Subject: EES comments on Environmental Impact Statement for Adaptive reuse of the Royal Hall of Industries – SSD_9726 - 1 Driver Avenue Moore Park

Subject: EES comments on Environmental Impact Statement - Adaptive reuse of the Royal Hall of Industries – SSD-9726 - 1 Driver Avenue Moore Park

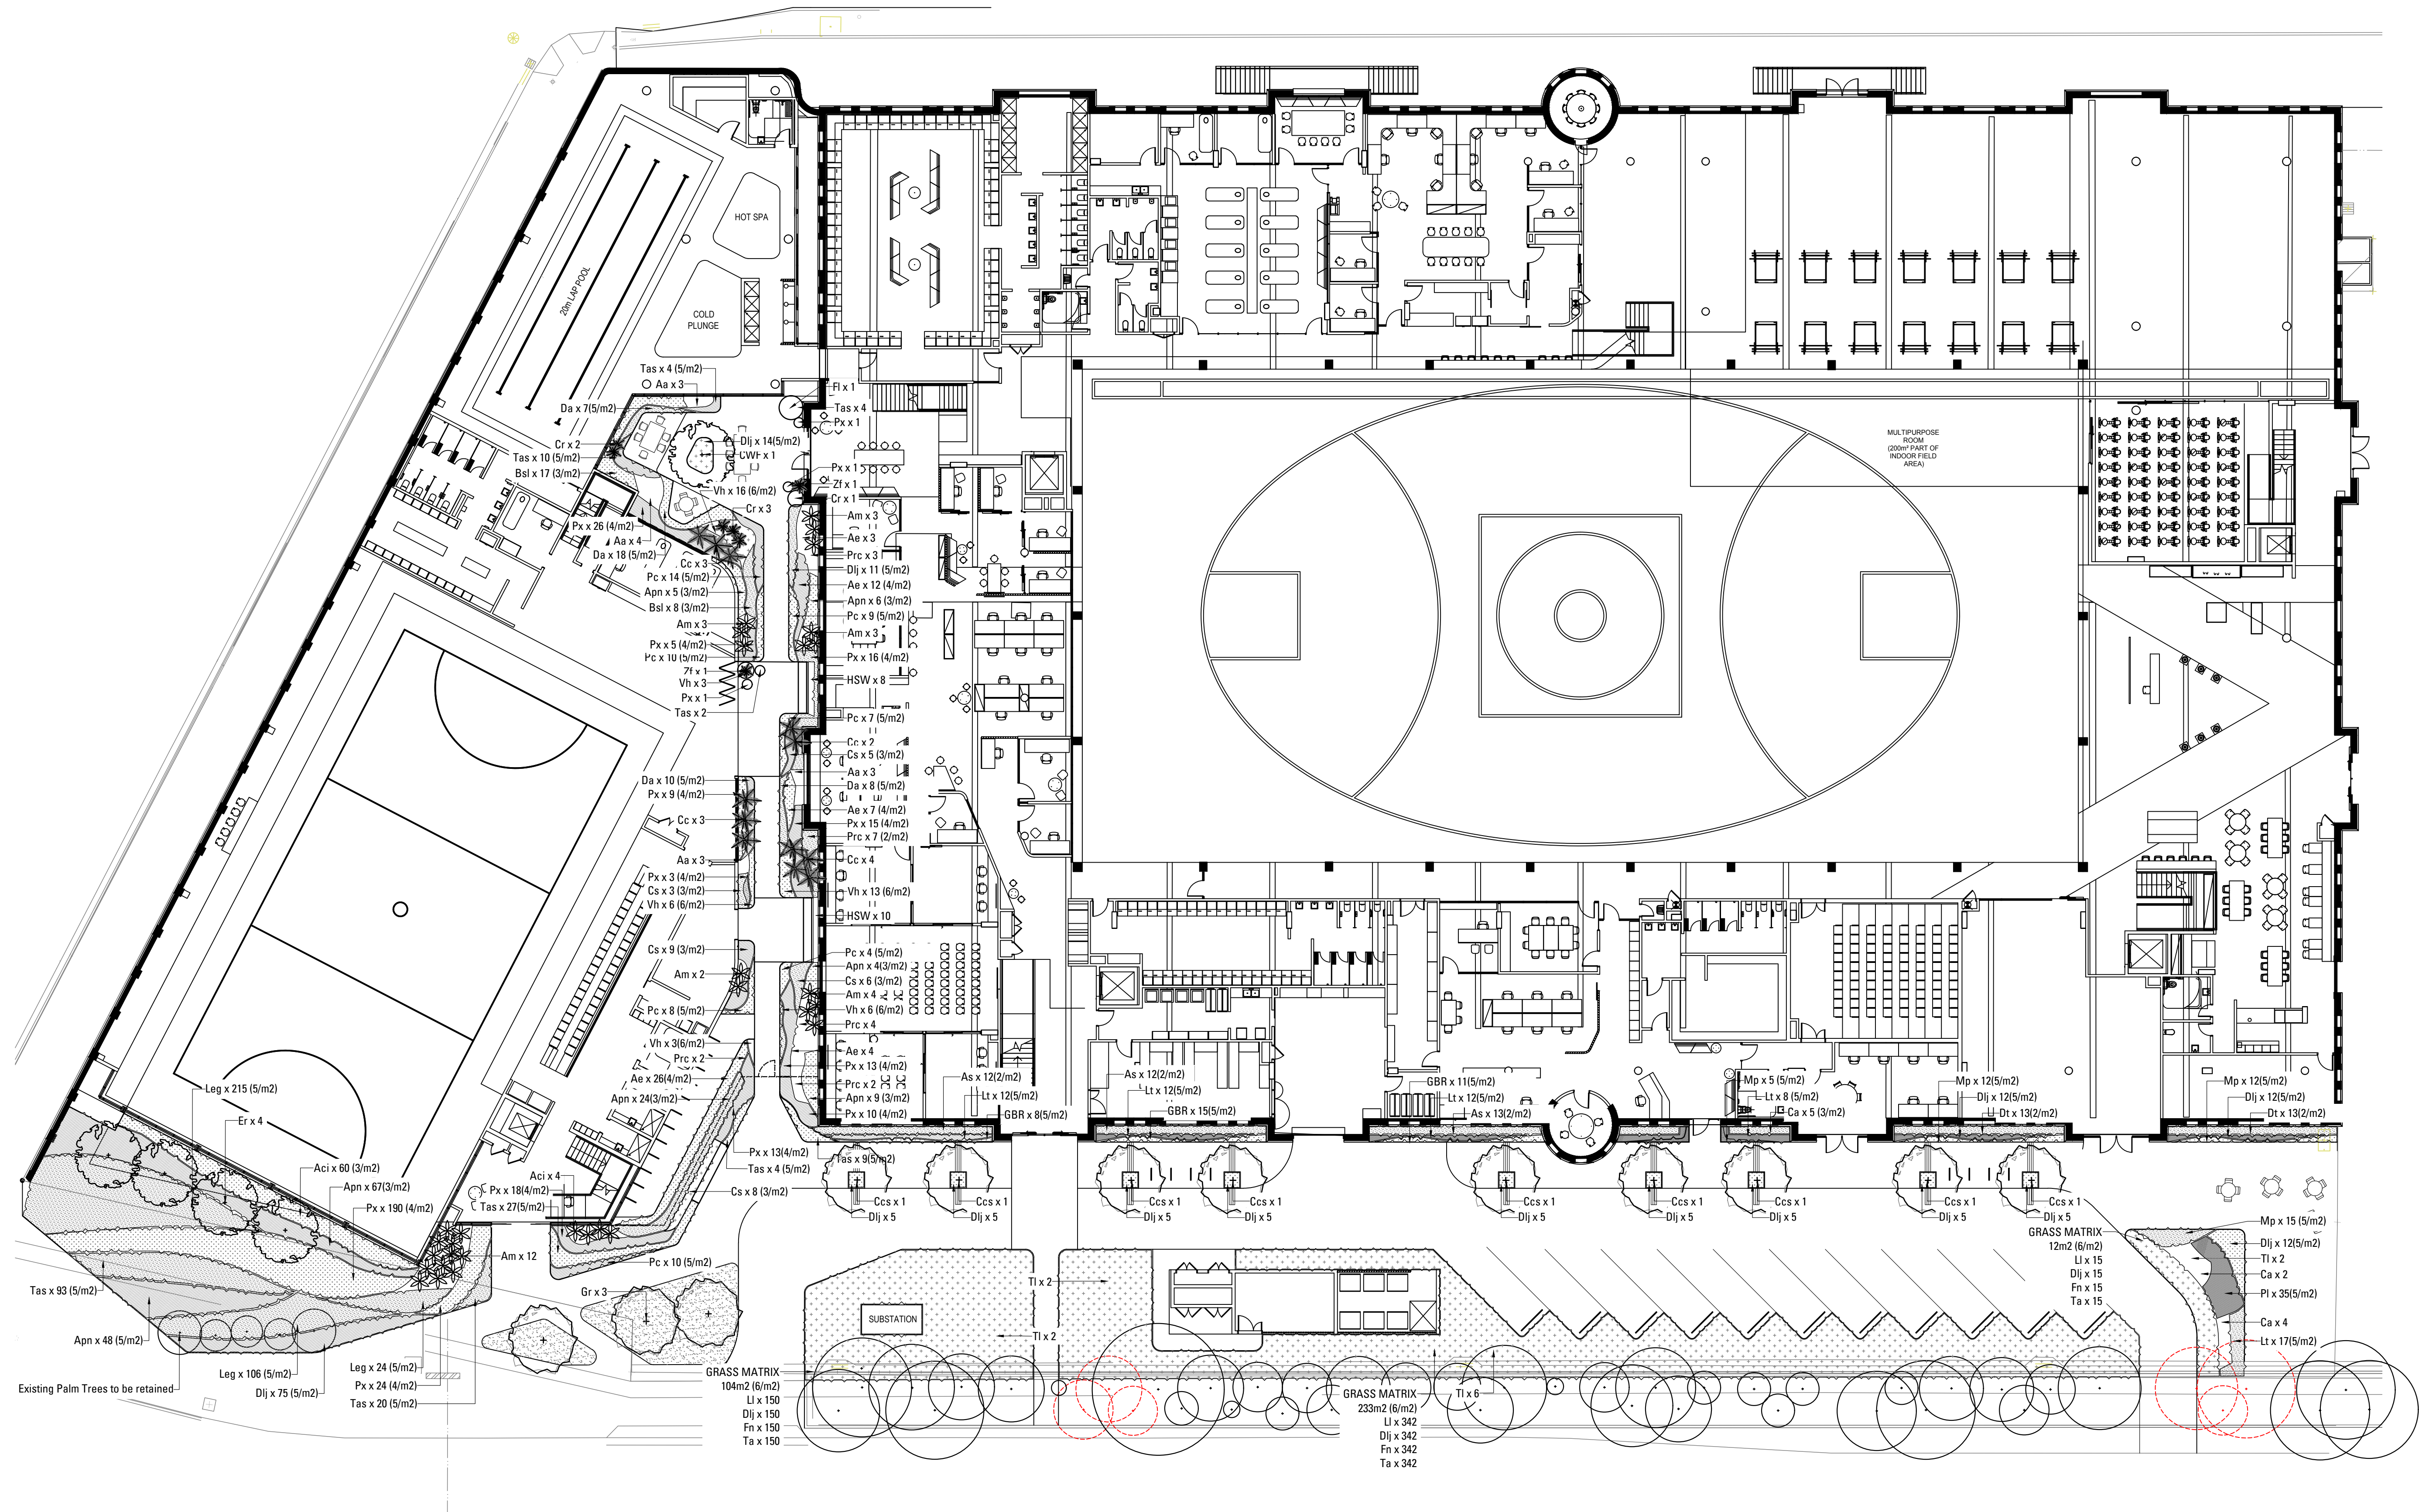
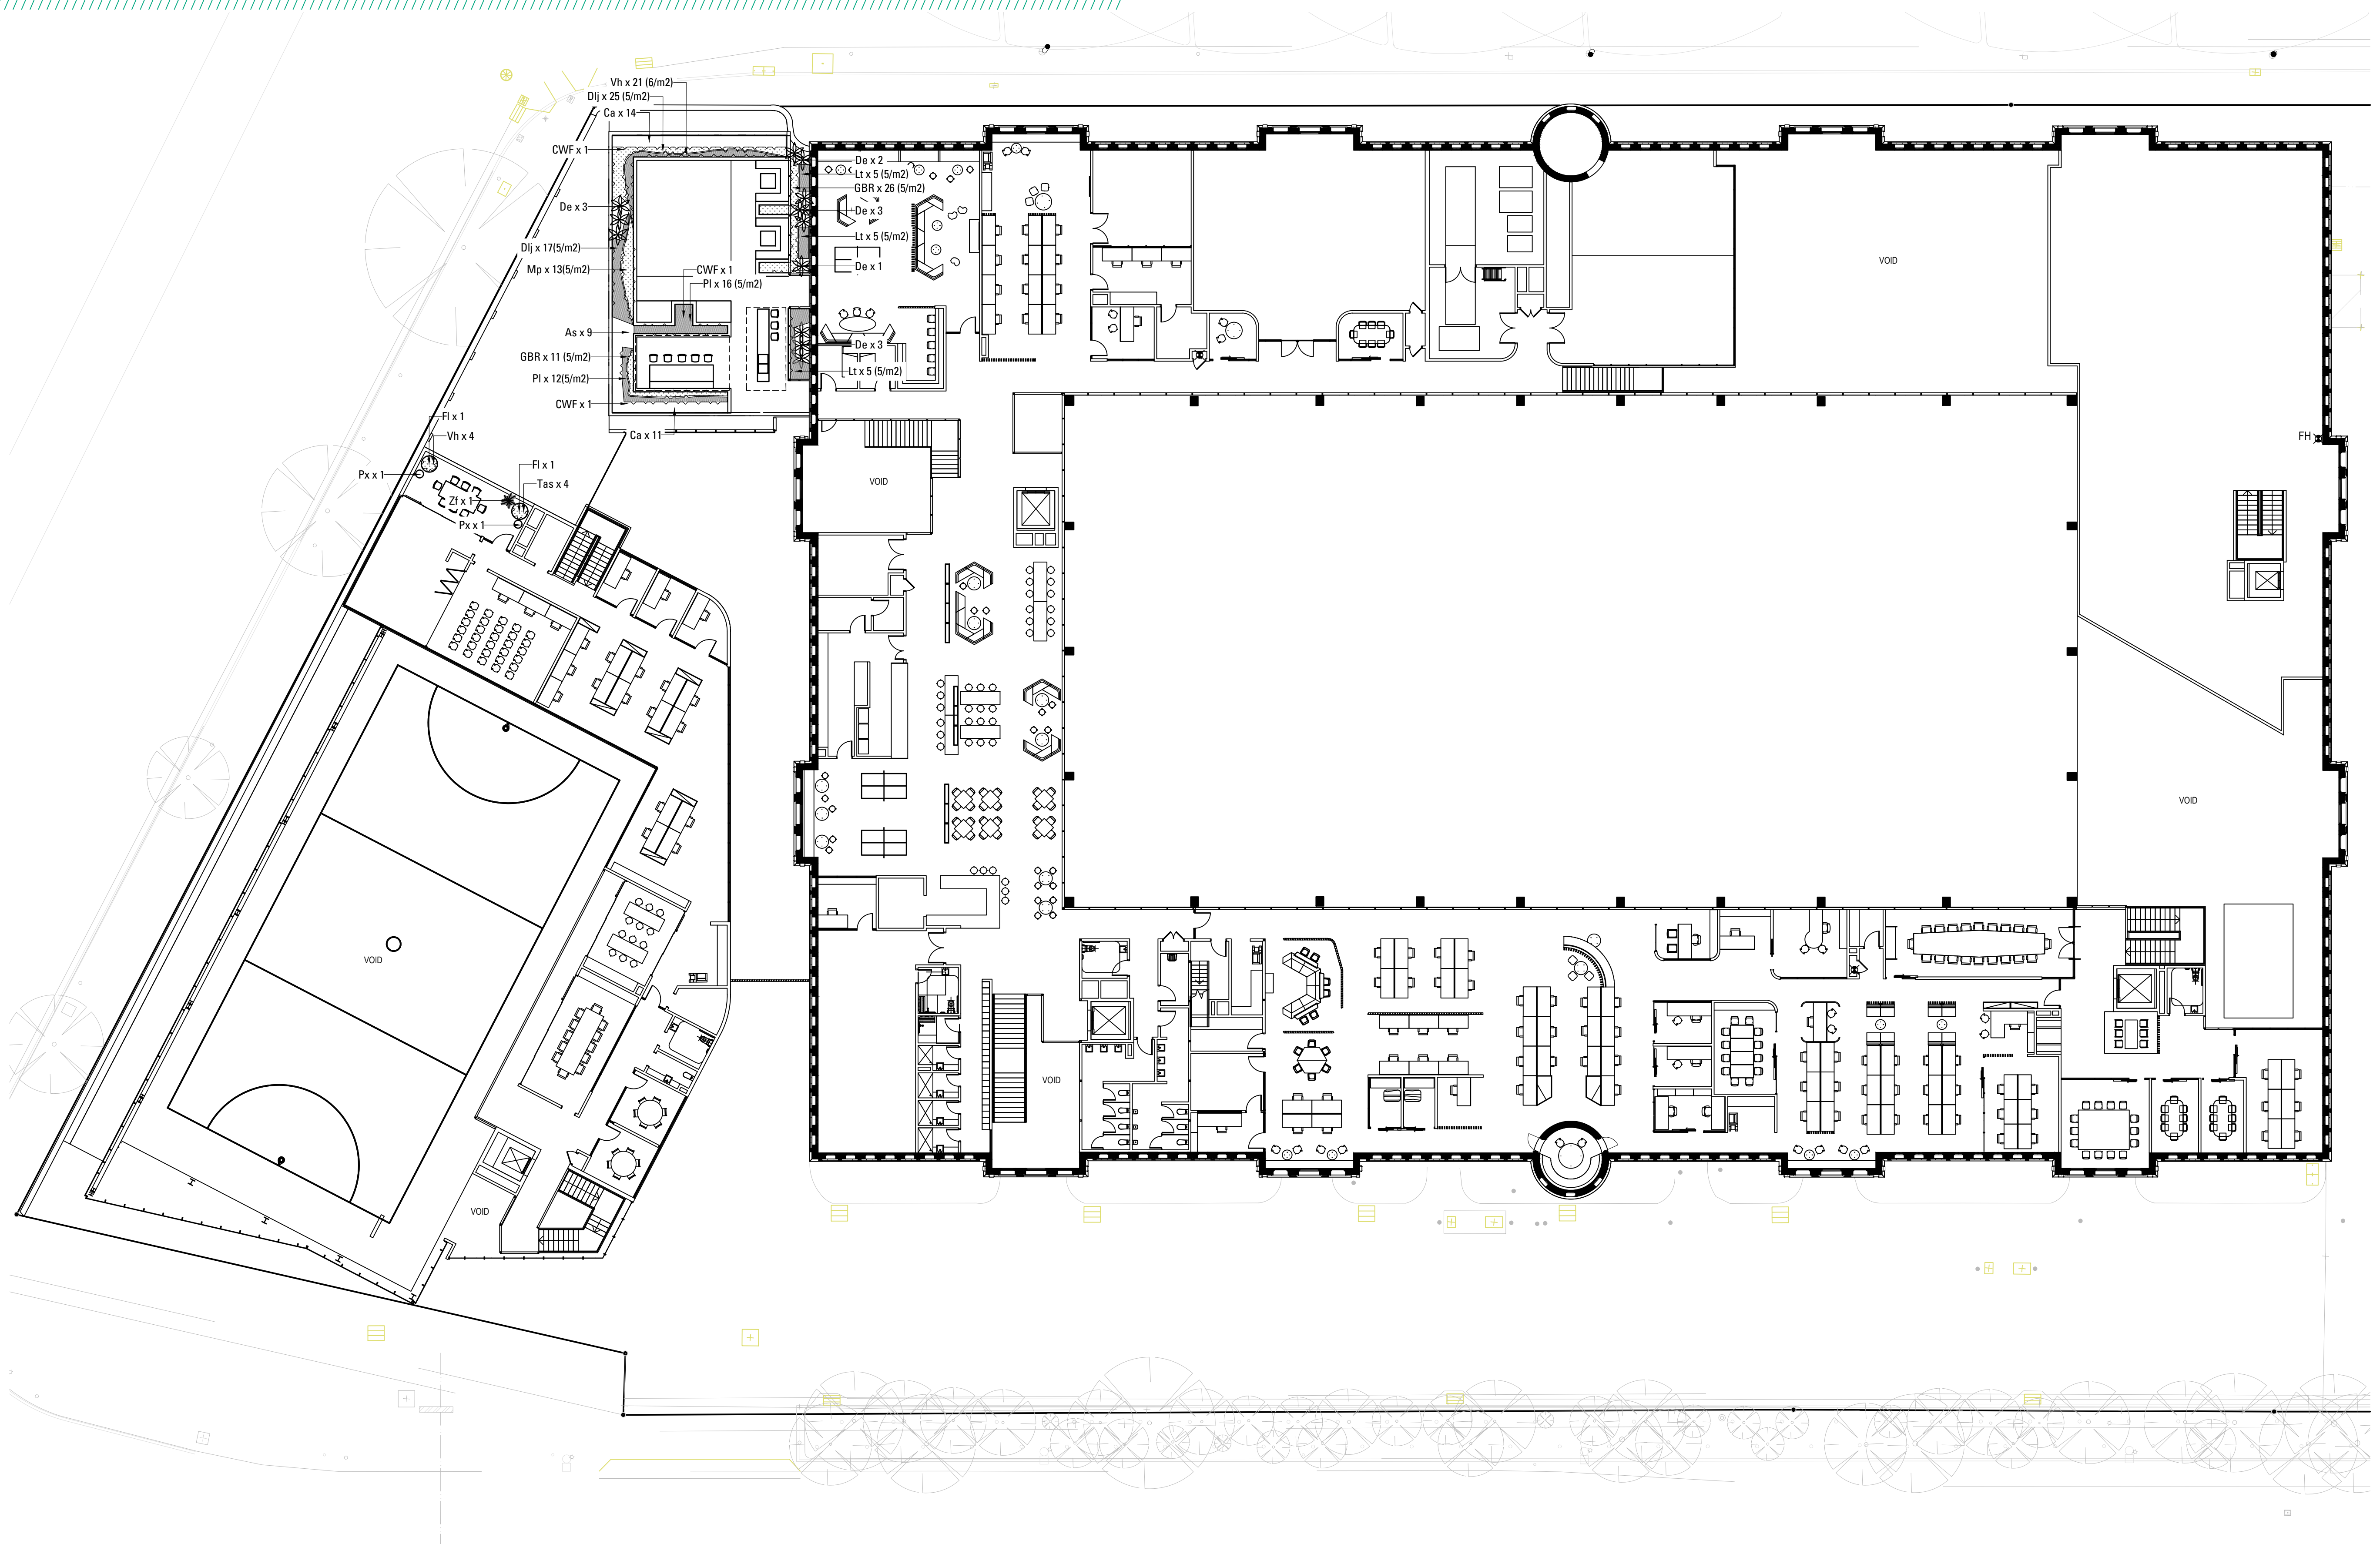
EES recommends the site landscaping/planting schedule uses a diversity of local native provenance trees, shrubs and groundcover species from the native vegetation community that once occurred in

this locality rather than plant exotic or non-local natives. If the project is approved, it is recommended a condition of consent is included to this effect and the Landscape Plan demonstrates that the plant species list comprises local provenance plant species.

- 1) The landscape plan shall use a diversity of local native provenance trees, shrubs and groundcover species (rather than exotic species or non-local native species) from the native vegetation community which once occurred in this locality.
- 2) The Landscape Plan shall include details on:
 - the native vegetation community (or communities) that once occurred in the locality
 - a list of local provenance tree, shrub and groundcovers to be used in the landscaping, the quantity and location
 - the pot size of the local native trees to be planted
 - the area/space required to allow the planted trees to grow to maturity.
- 3) Trees removed by the development shall be replaced at a ratio greater than 1:1.
- 4) The landscaping shall use advanced and established local native trees preferably with a plant container pot size of 100 litres, or greater to increase urban tree canopy cover.
